KIRKLEES METROPOLITAN COUNCIL INVESTMENT & REGENERATION SERVICE

DELEGATED DECISION FOR DISCHARGE OF CONDITION A1 - NOTIFICATION OF A PROPOSED DEVELOPMENT UNDER LOCAL OR PRIVATE ACTS OR ORDER

Reference no. 2026/CL/90696/W

Description	Prior approval for alterations to bridge MVL3/71
--------------------	---

Drawing Title
**Prior Approval -
MVL3/71 Britannia Road, Golcar
Existing & Proposed Elevations**

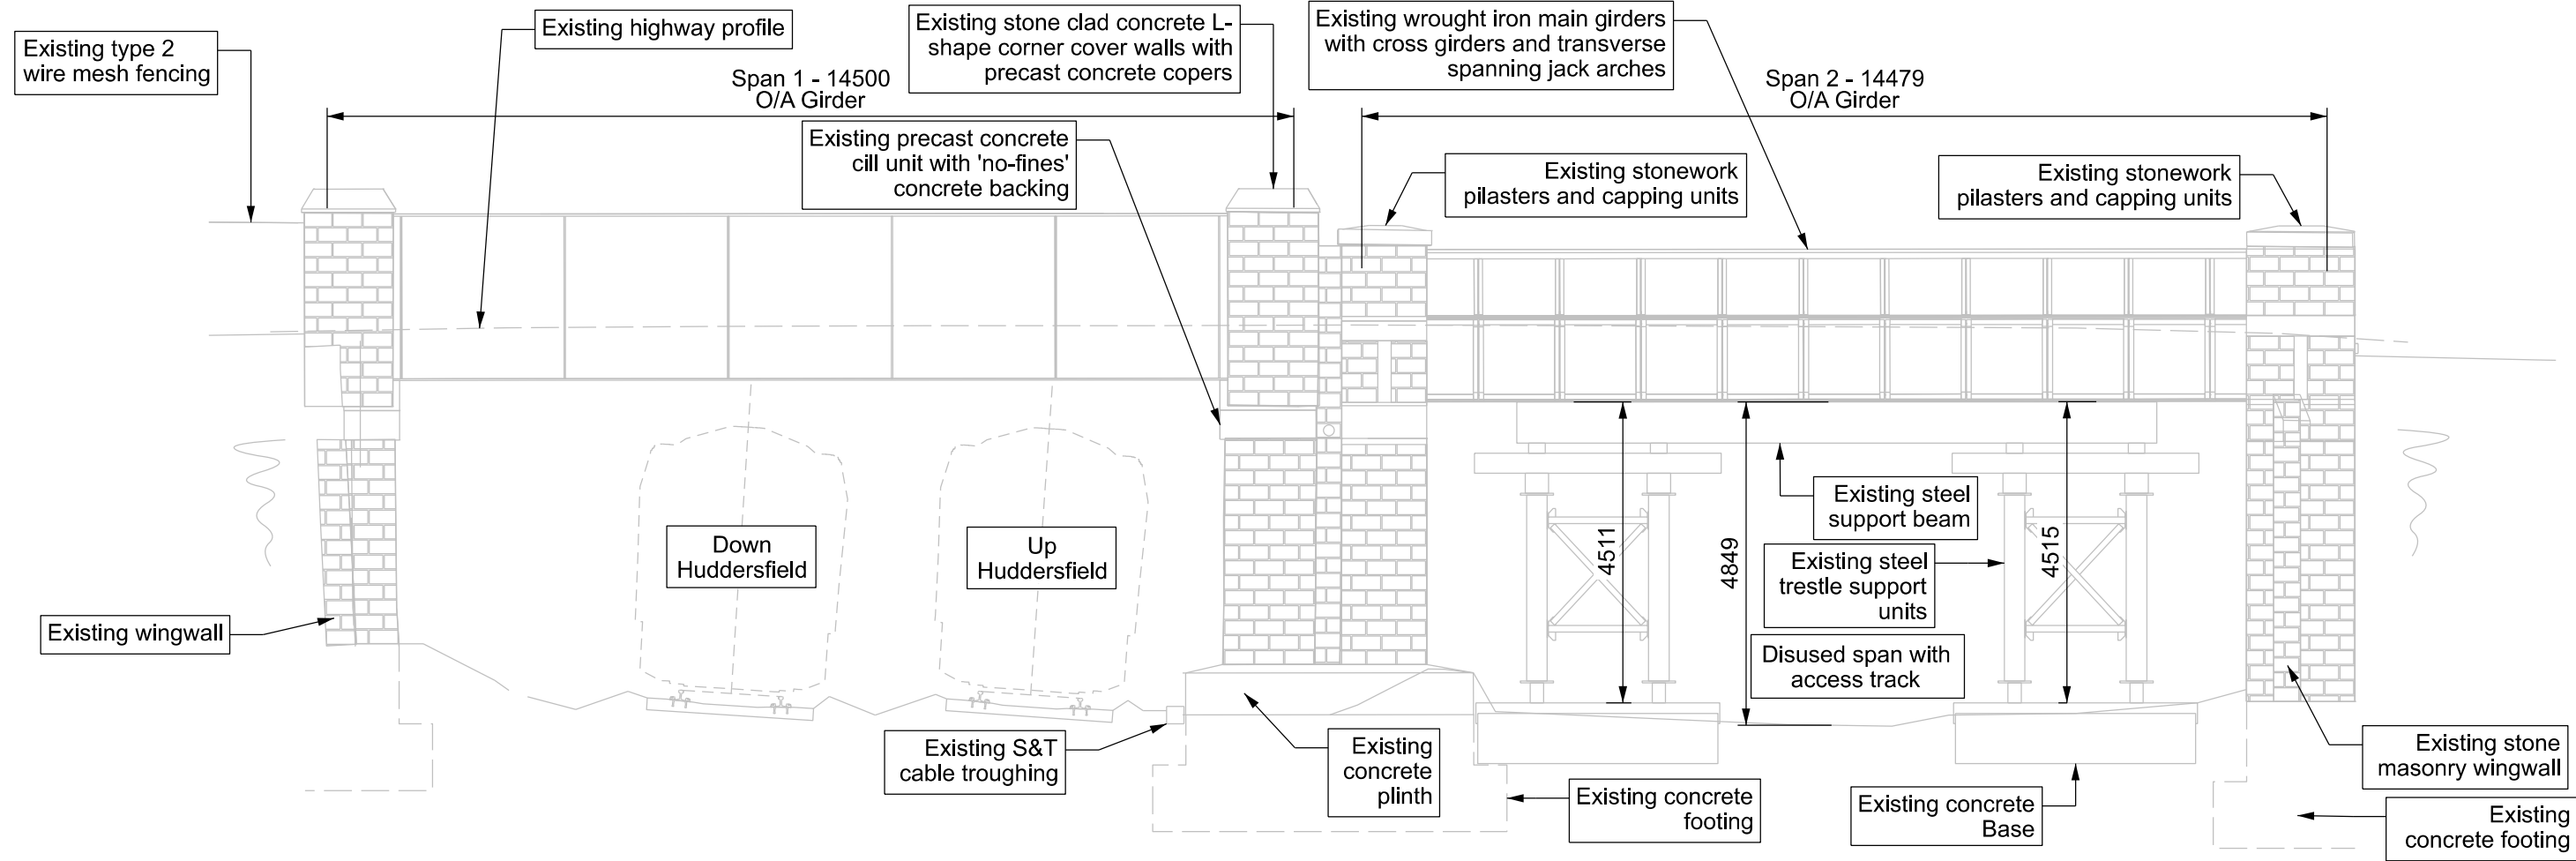
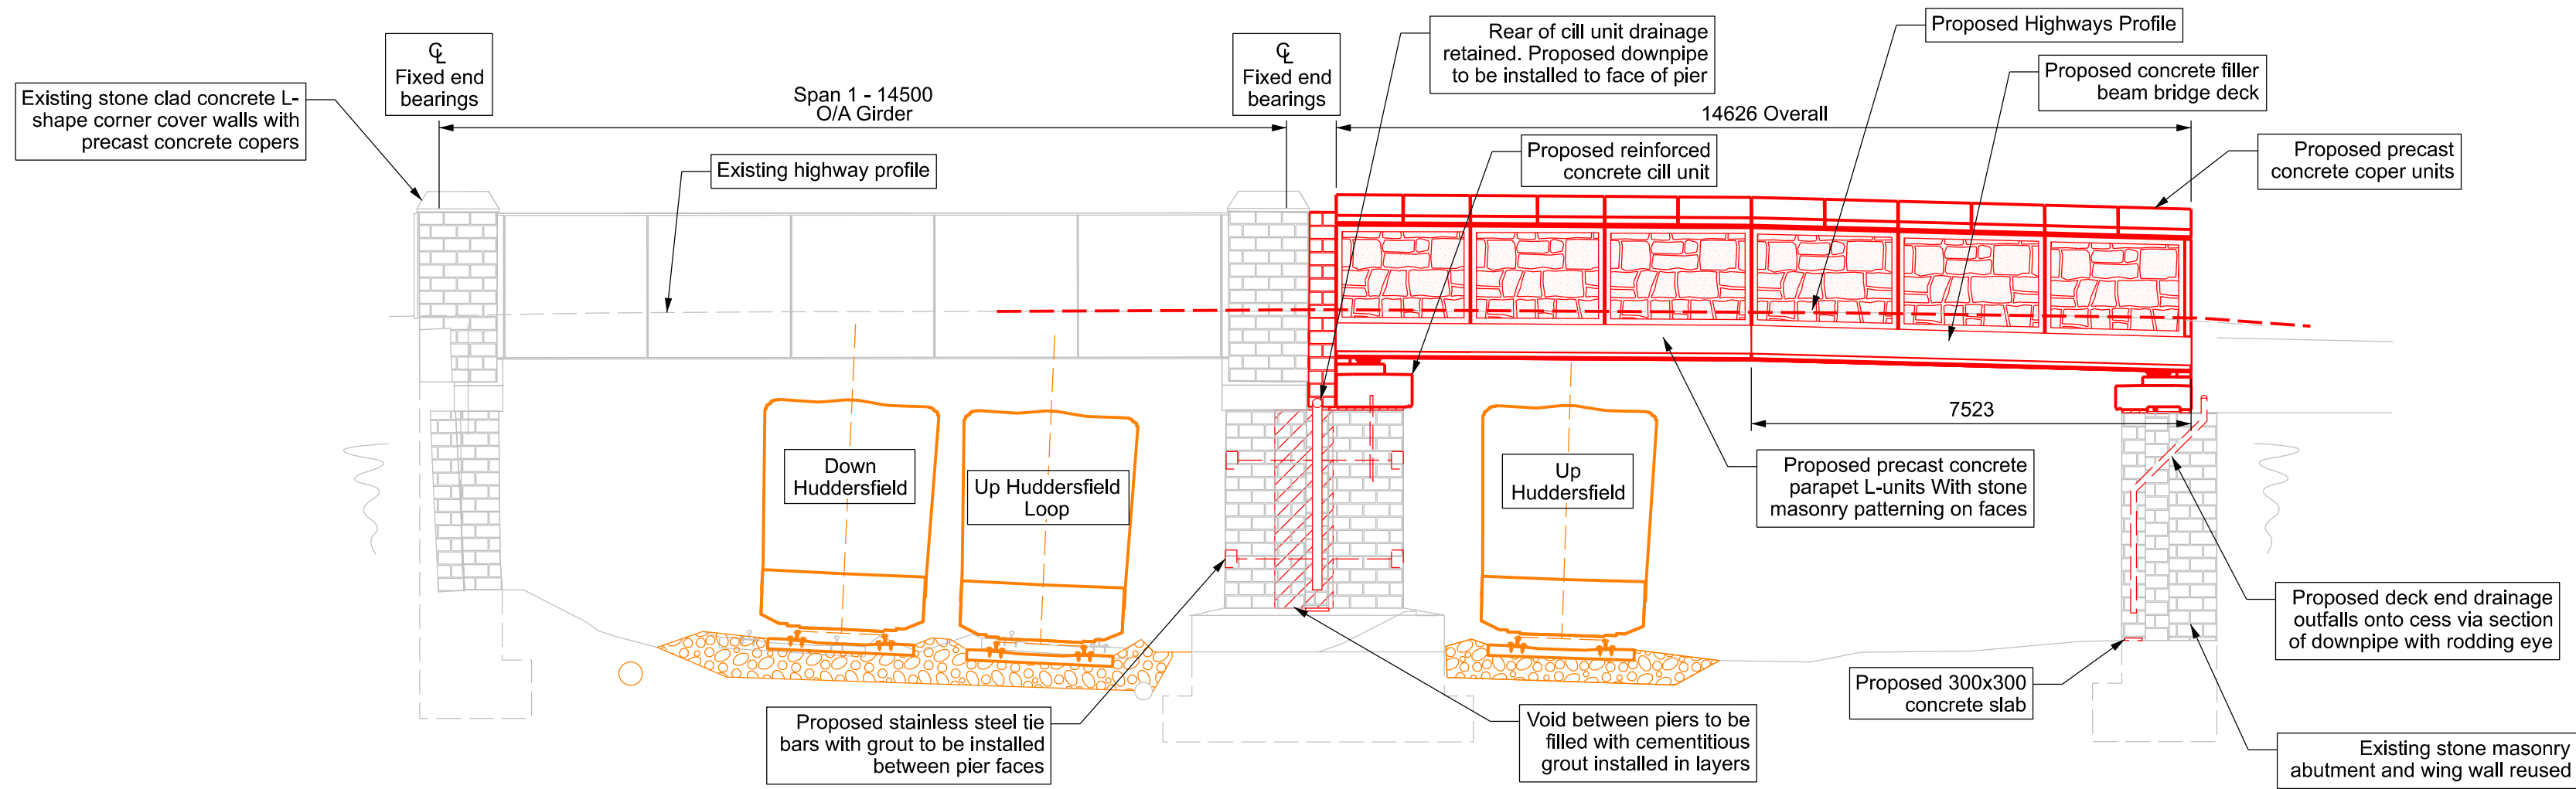
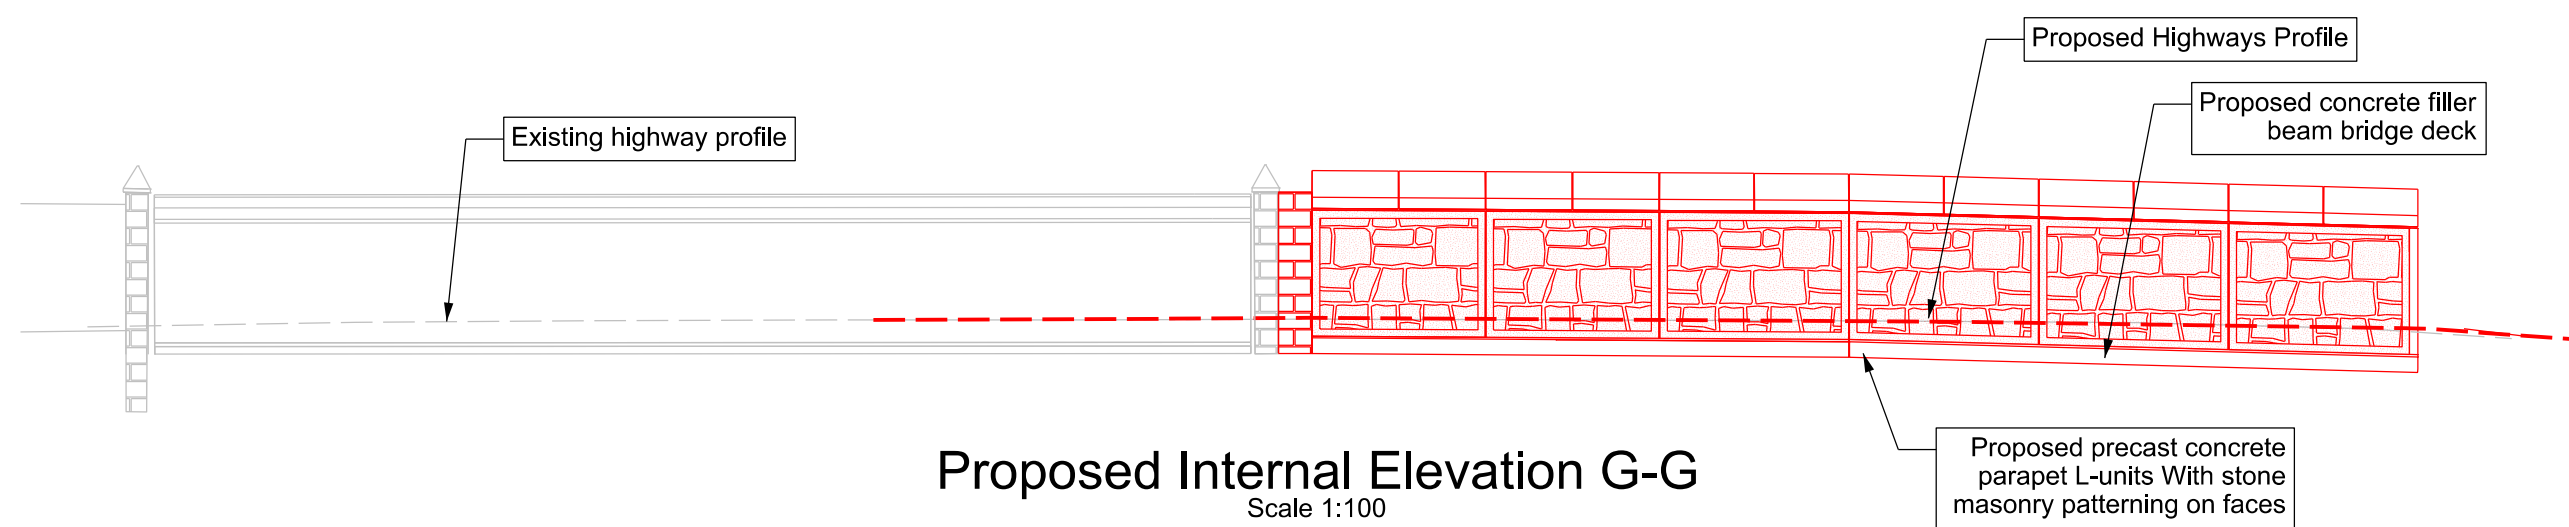
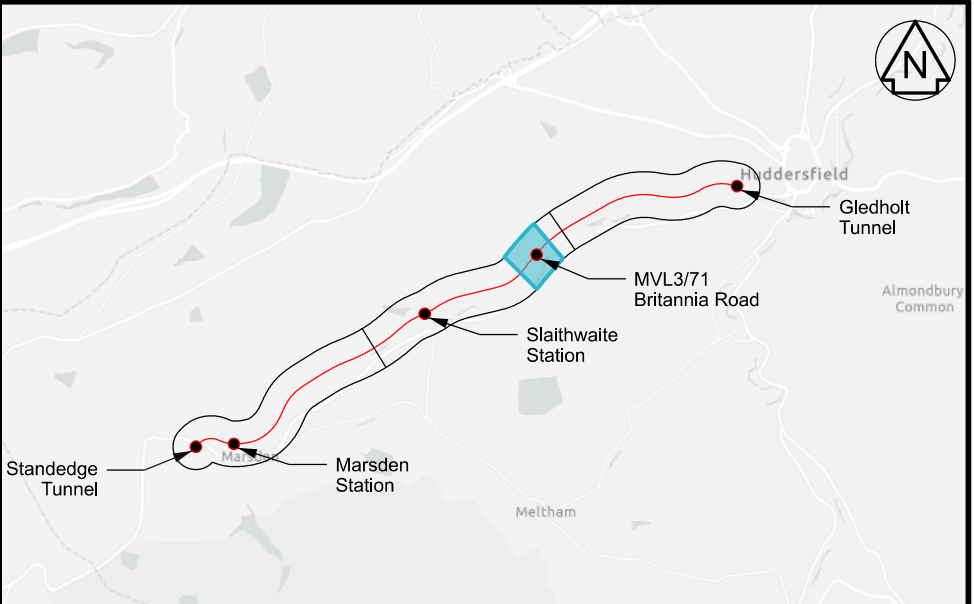
- *The pre-cast concrete L-units shall be a finished with natural stone cladding design pattern to match the natural coursed stones below. The concrete shall match the existing natural stones by colour, texture and coursing.*
- *The GRP handrail shall be finished in a black or green colour*

The applicant was unable to agree to the use of natural stone at this stage and requested a meeting to discuss. The meeting was held between the applicant, Conservation and Design Officer and Planning case officer. At the meeting it was advised that the use of an alternative material to natural stone could be acceptable, however, details of the material, colour and patterning would need to be agreed. The applicant agreed to provide options.

1. Notwithstanding the submitted plans, a sample of the parapet finish[es] shall be submitted to and approved by the Local Planning Authority, prior to their installation. The external treatment of the parapet finish[es] shall reflect the retained stonework of the bridge in terms of colour, texture, finish and coursing.

- The submission of material finish/detail to be agreed by the LPA
